Our Reference: SYD20/00855/02

Departments Reference: SSD-8571481

EXHIBITION OF EIS - TAFE NSW WESTERN SYDNEY CONSTRUCTION CENTRE OF EXCELLENCE HUB - 2-44 O'CONNELL STREET, KINGSWOOD

Attachment A

APPENDIX C

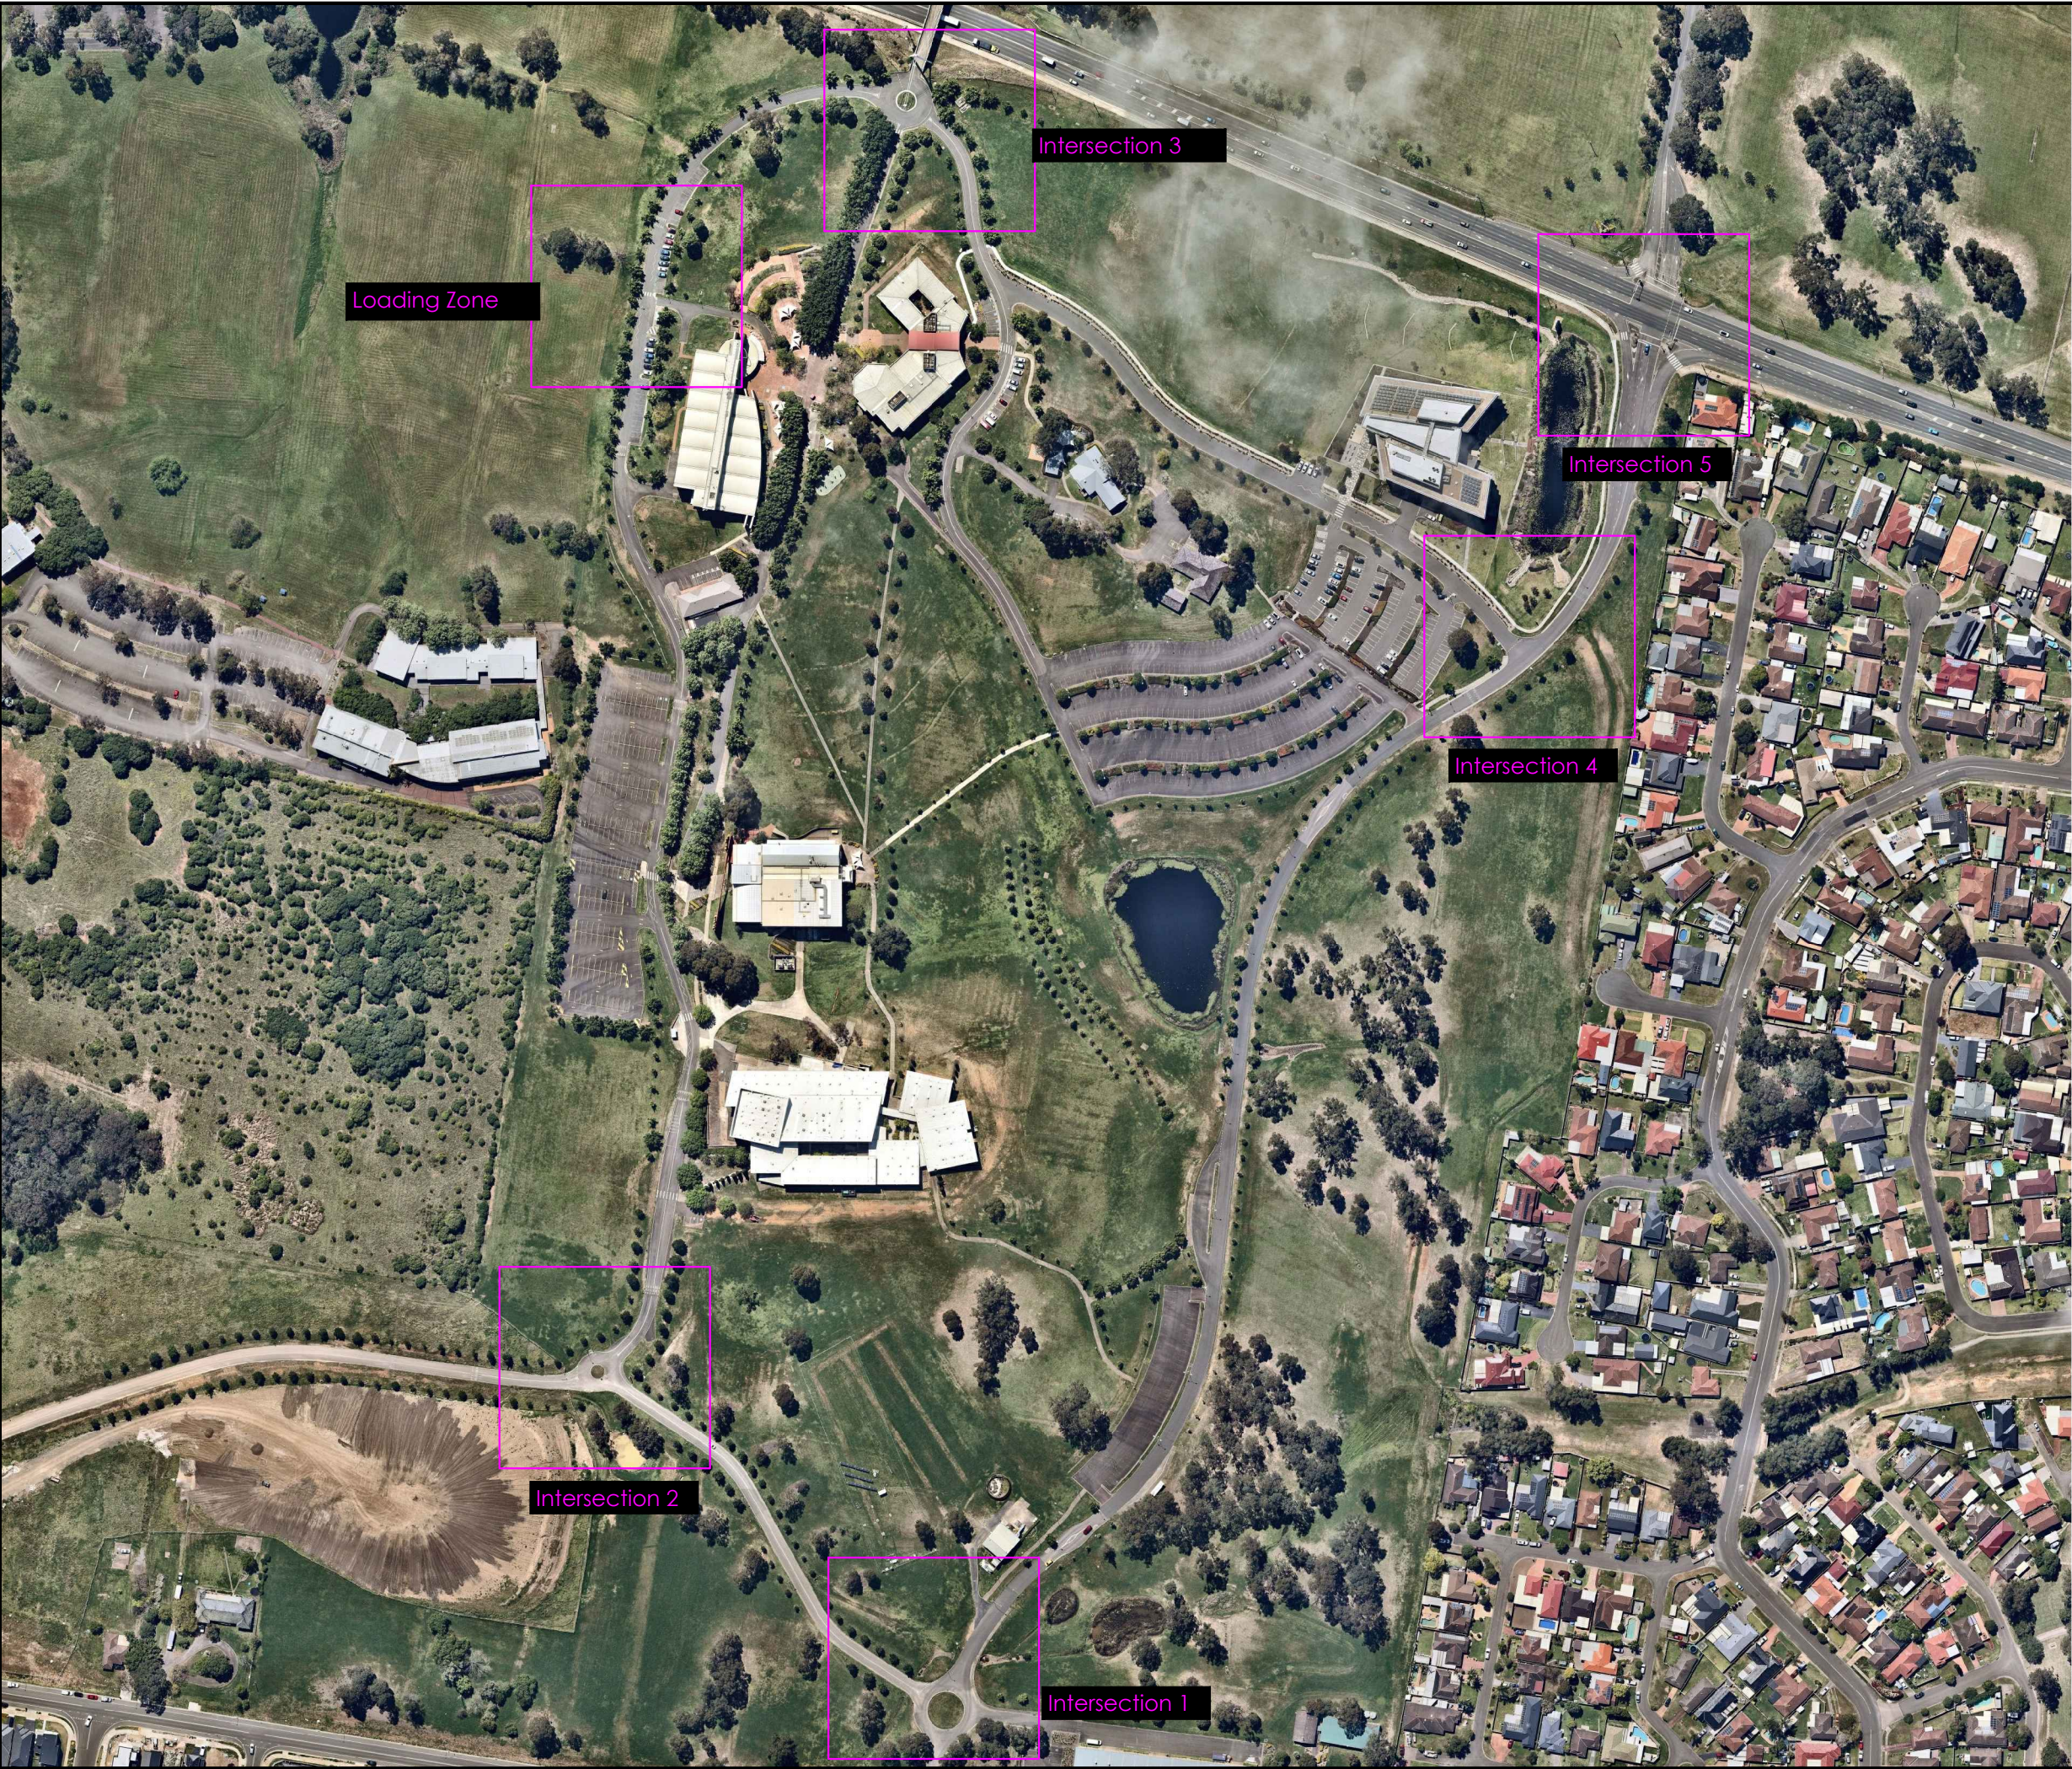
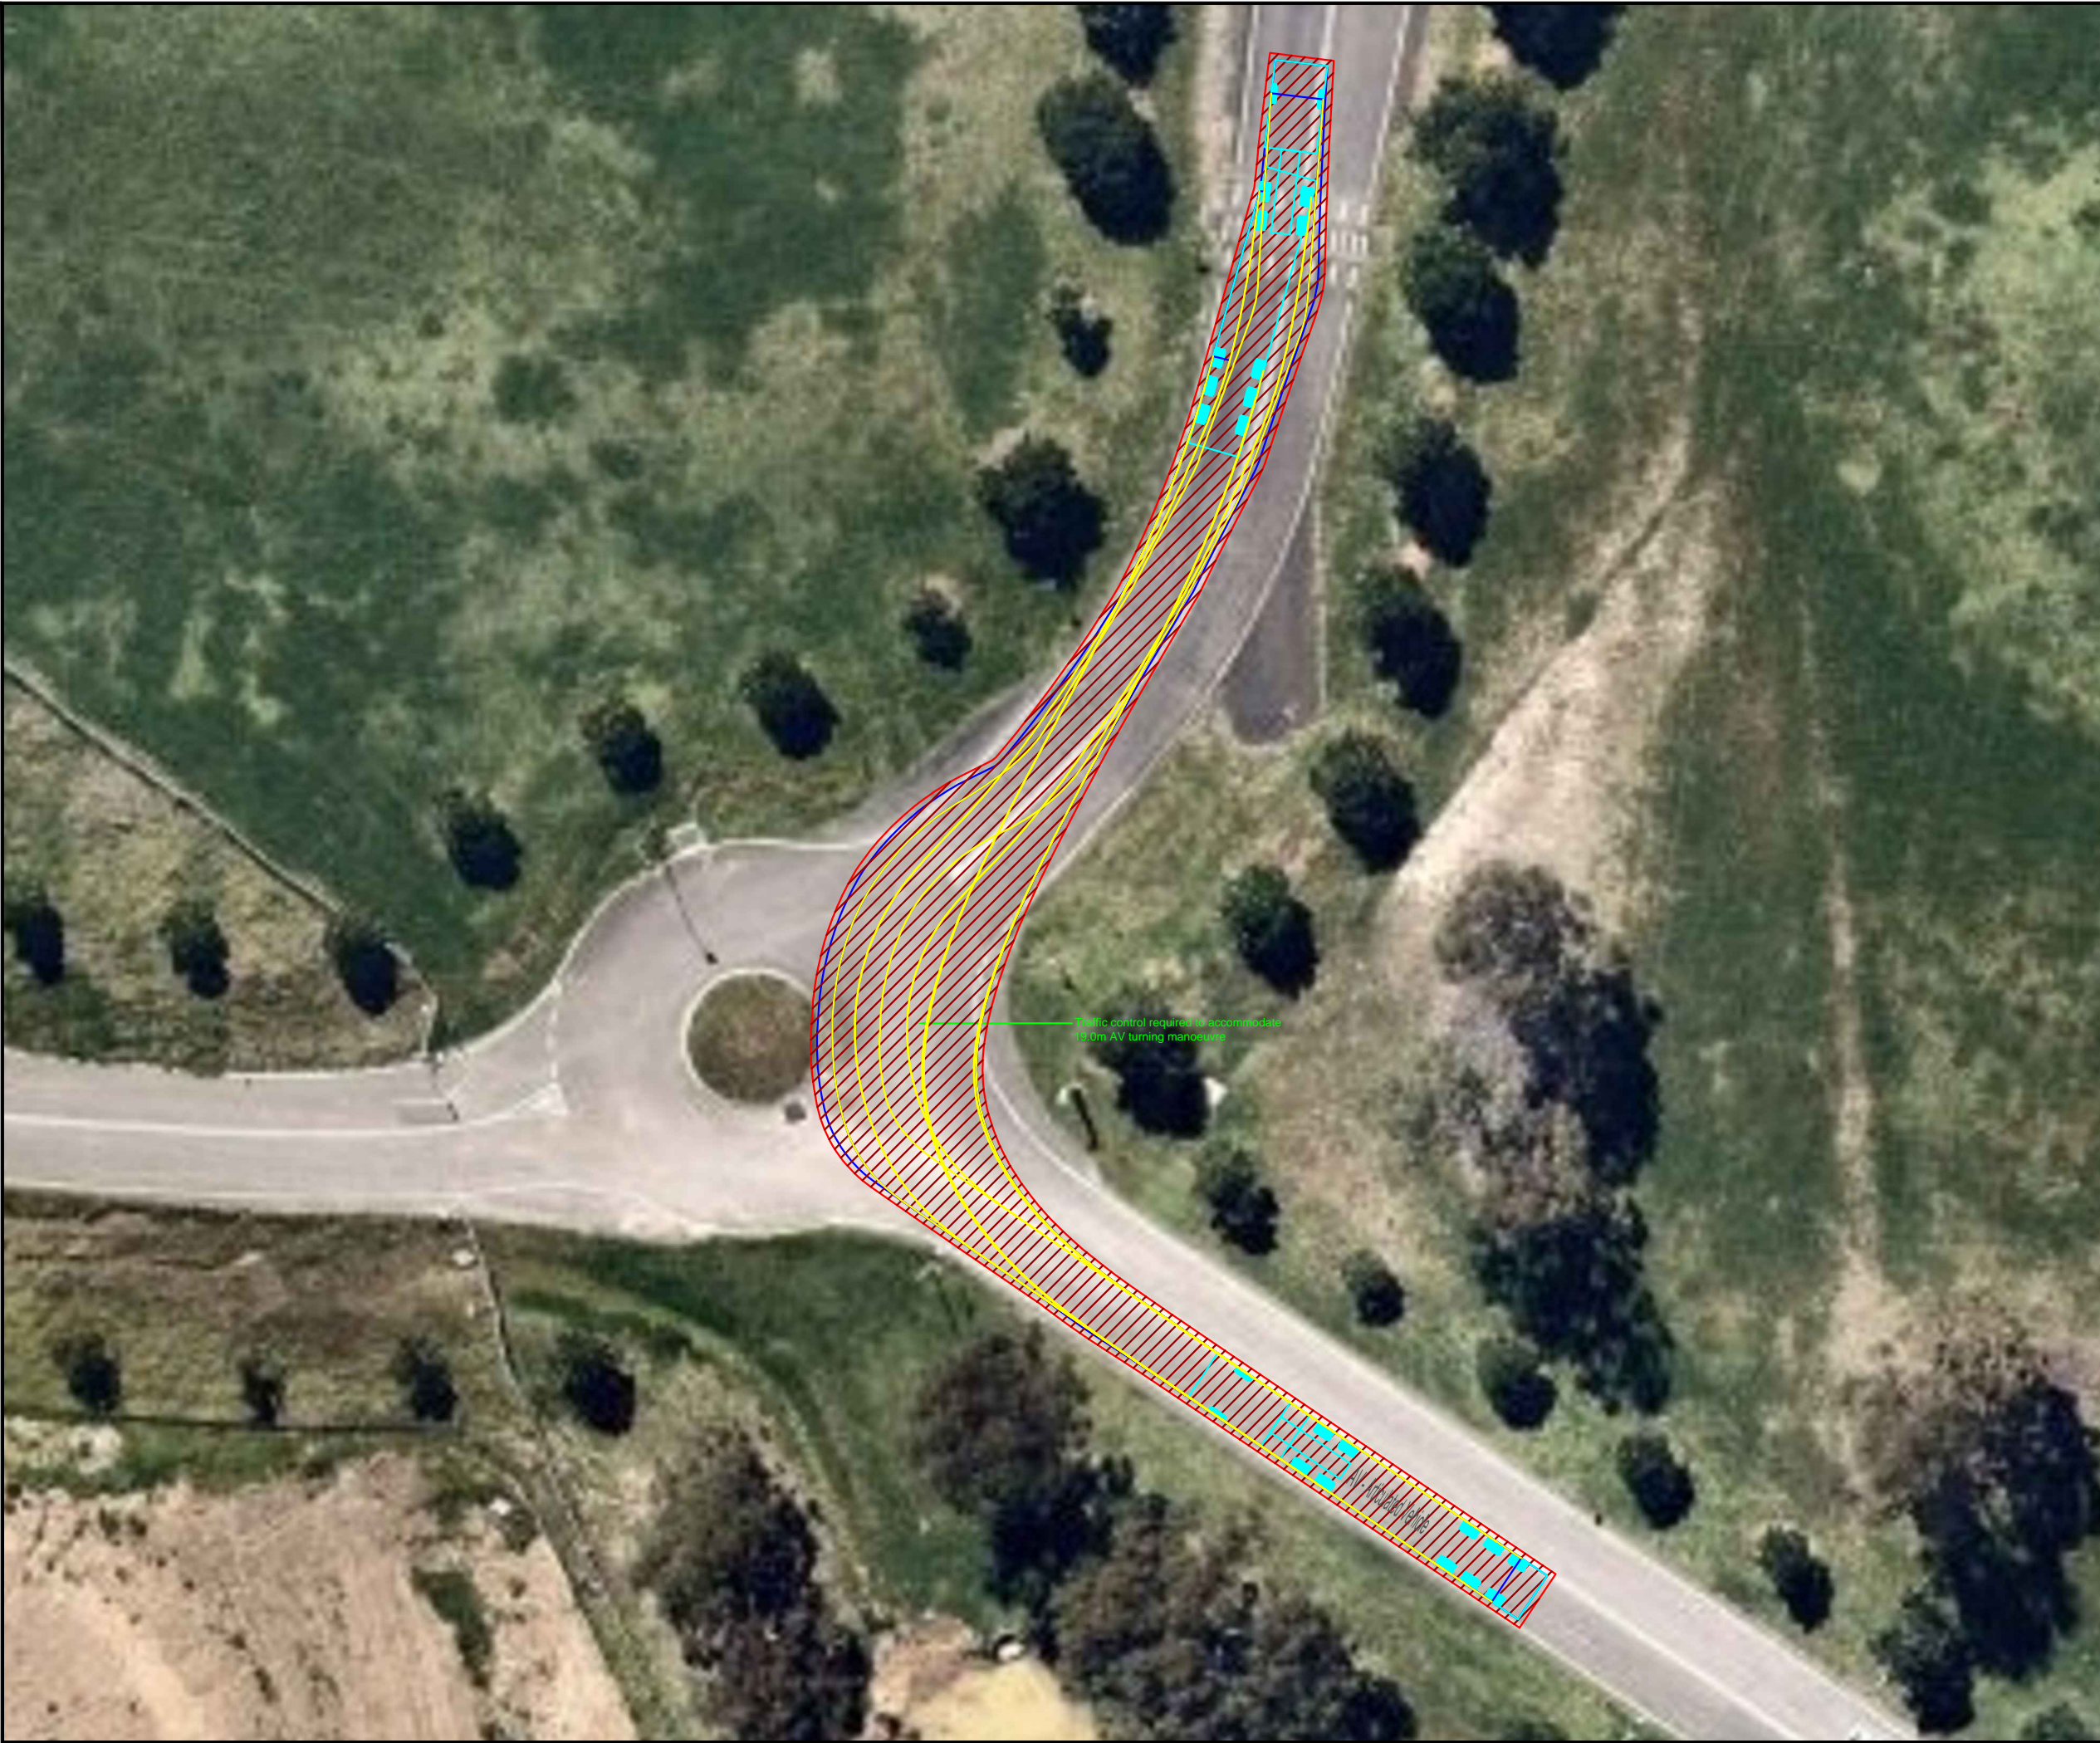
- a. Section 5.1.2: The truck routes will be using the GWH/Western Sydney University intersection. Modelling of this intersection is required to show the results of the intersection performance on each stage of work.
- b. Appendix C Loading Zone Swept Paths: Traffic Controller is recommended to ensure there is no conflict between construction trucks and vehicles / pedestrians using the carpark.

TfNSW requests the abovementioned information be addressed and the CTMP be updated to reflect the outcomes.
